**Consultation Response from Alan Smith,
KC Waste Strategy (Refuse & Recycling)**

2025/92443 Huddersfield Open Market, Brook Street, Huddersfield, HD1 1DY

Date Responded: 13/10/2025

DRAWING General Arrangement - Storage Compound
Plan, Elevations and Sections as Proposed

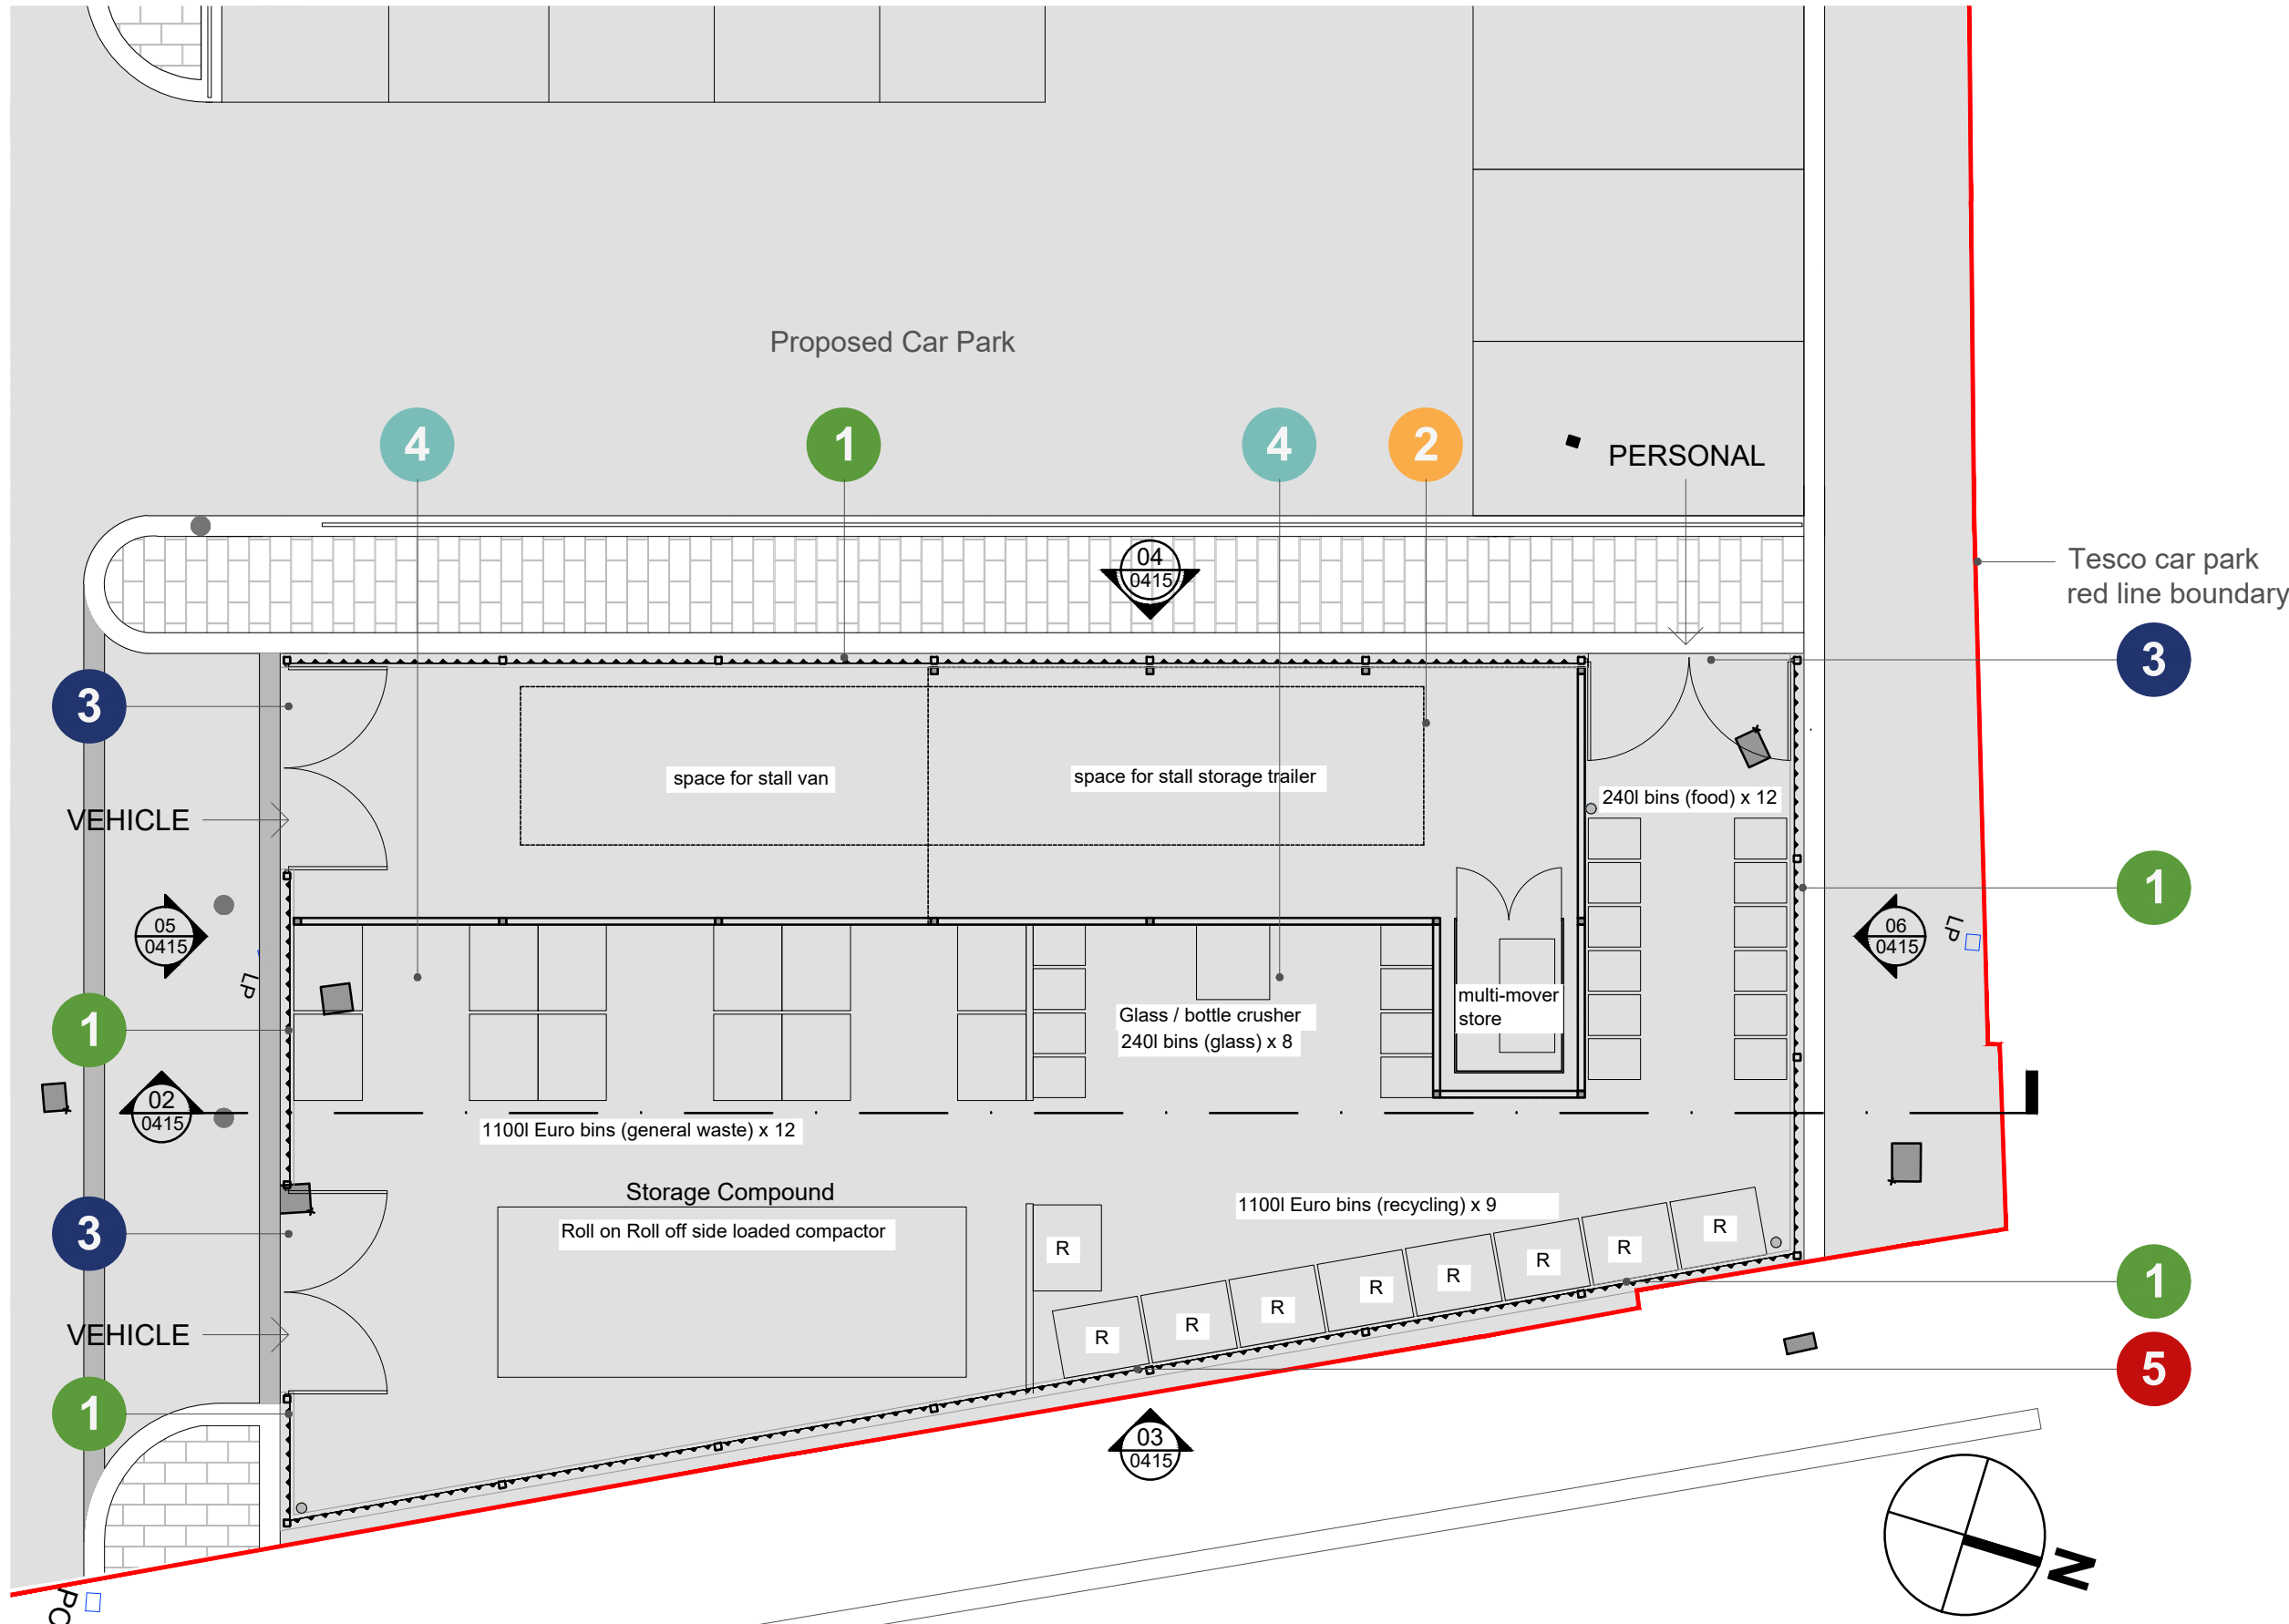
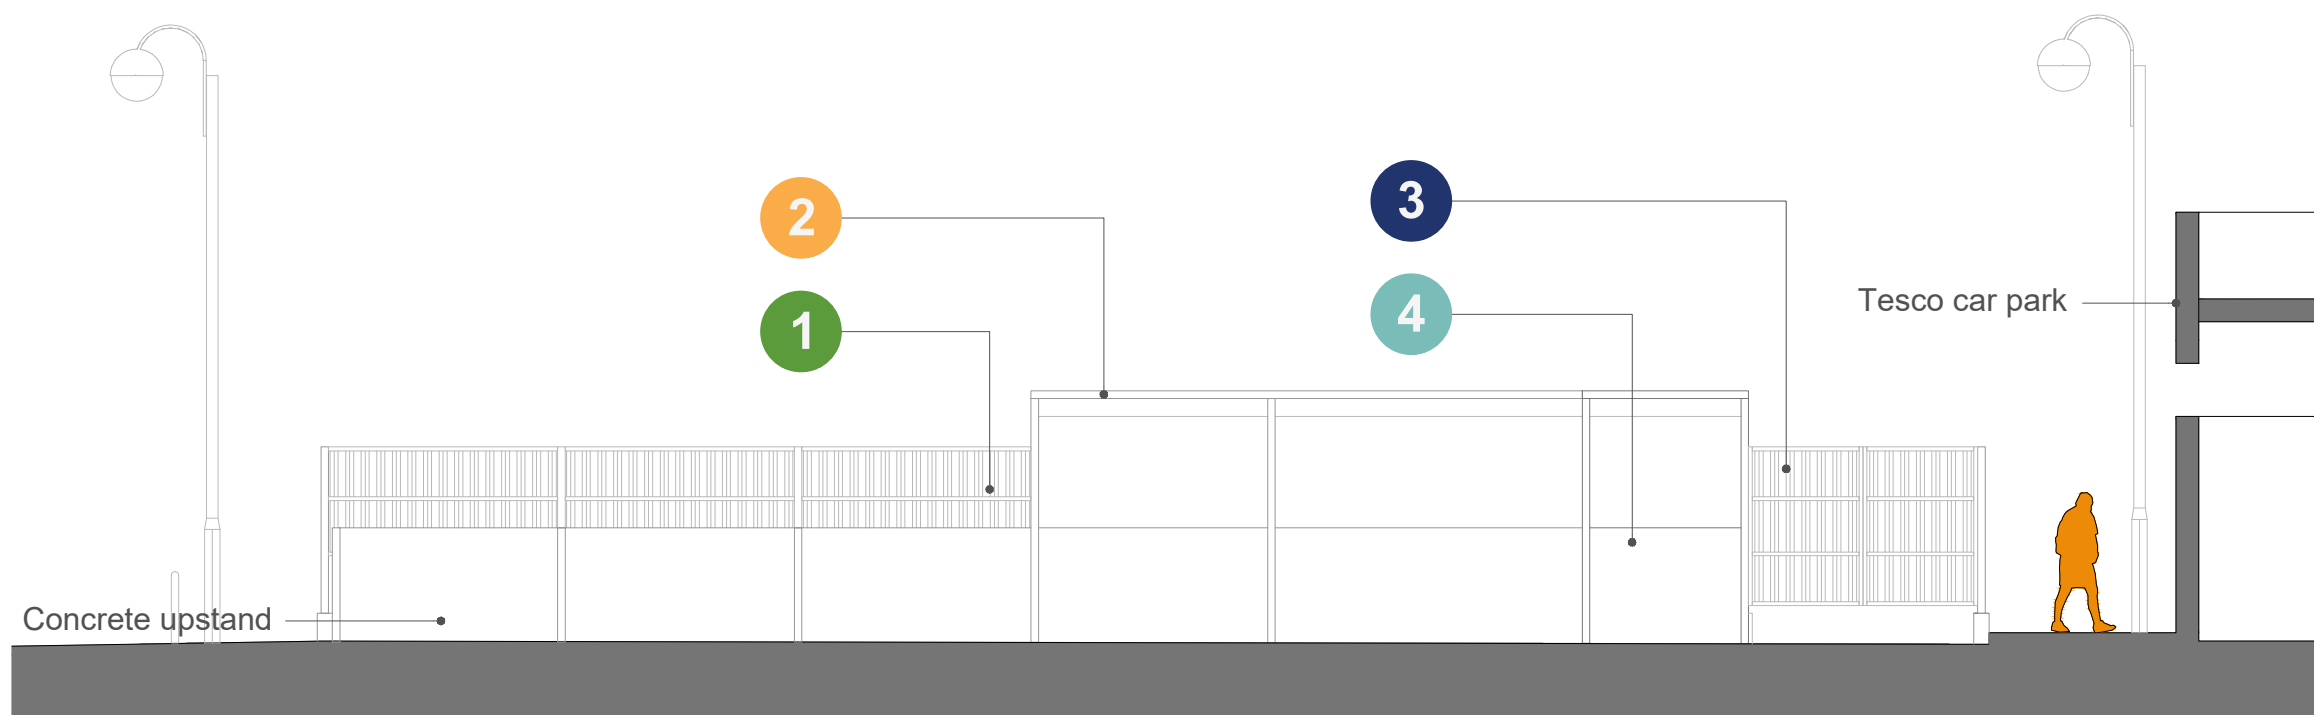
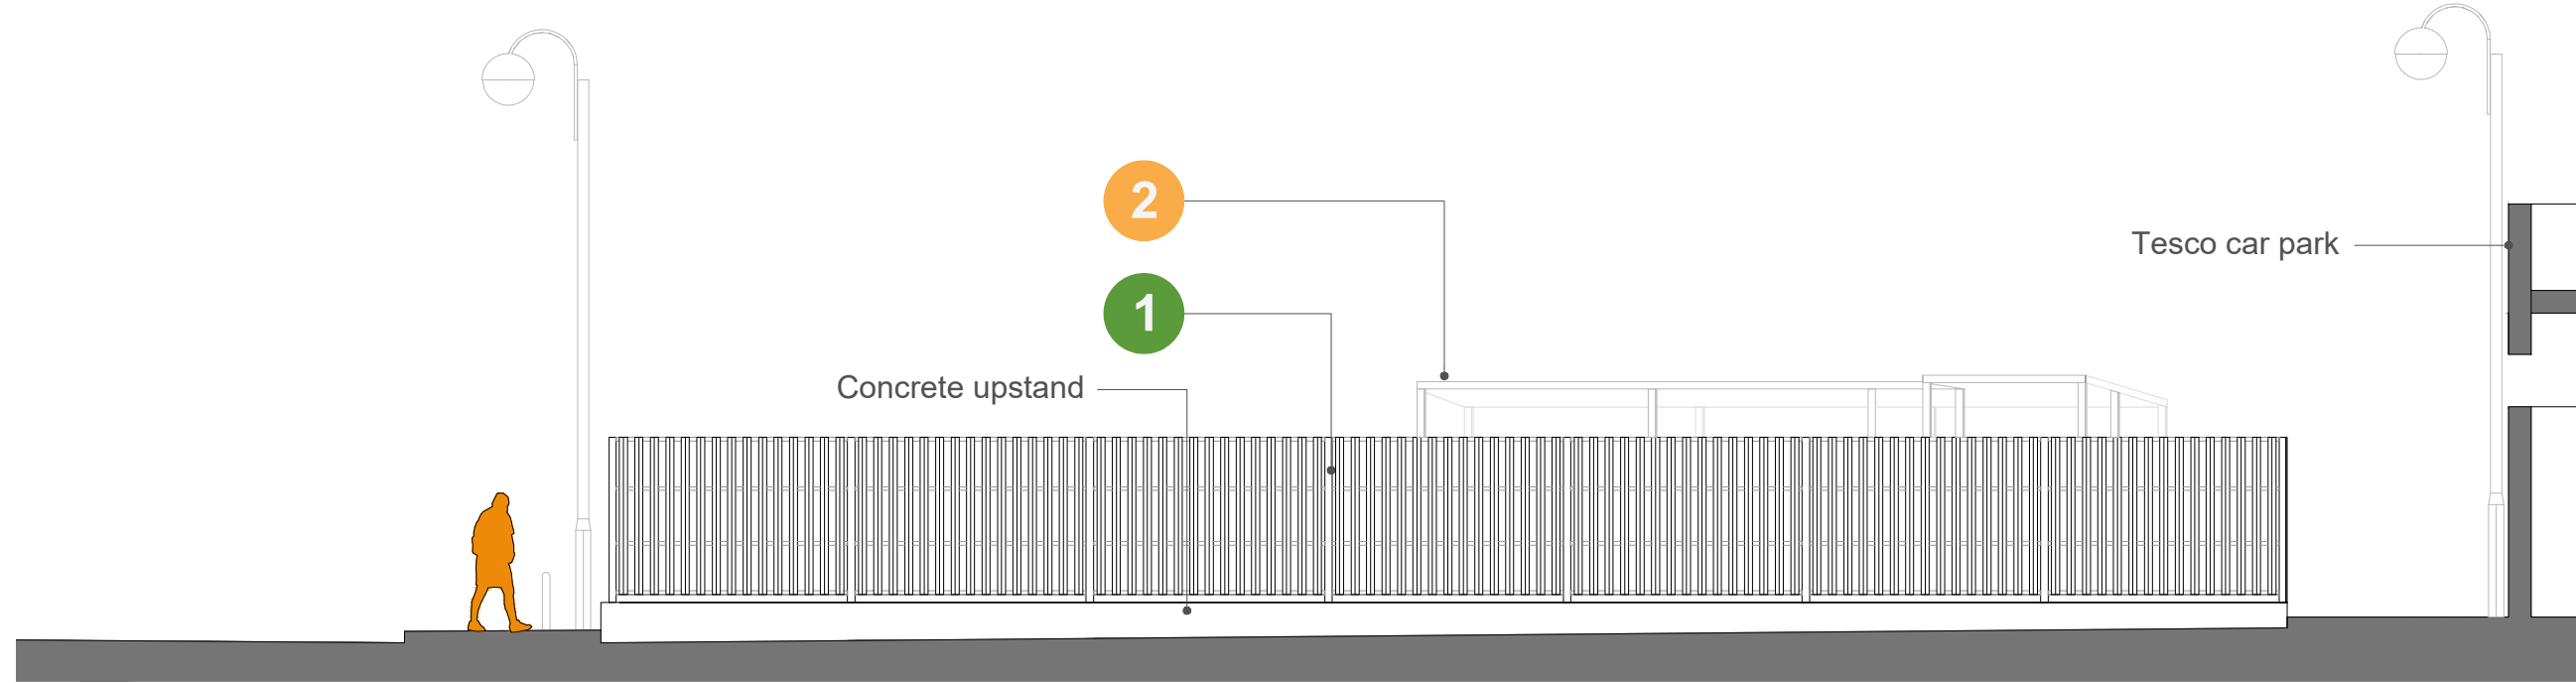
The developer has submitted the Waste Management Strategy for the site, including the design for the new bin store shown below.

- As well as a compactor for cardboard the compound also holds bins for general waste and recycling waste including bins for glass and food waste. This should ensure that the market meets the requirements of Simpler Recycling Legislation.

- The waste stores should be secure to prevent theft, unauthorised use / fly tipping or rough sleeping. If the doors to the bin store are to have a key / keypad to secure access these details will be required by the collection staff. The bin store should be of suitable dimensions to accommodate the necessary bins and constructed in compliance with the details specified in the design guide.

- The waste stores should be screened to avoided impact on street scene and be secure to prevent unauthorised use, minimise risk of arson and avert use by rough sleepers. Details of bin store construction requirements can be found in the Kirklees Waste Management Design Guide 2020.

- Bin store surfaces should be durable and waterproof enough to withstand heavy duty cleaning such as power washing. The storage area needs to have suitable drainage, with water discharging into a sewerage drain, (not into surface water or onto the highway), to allow the washing of bins.
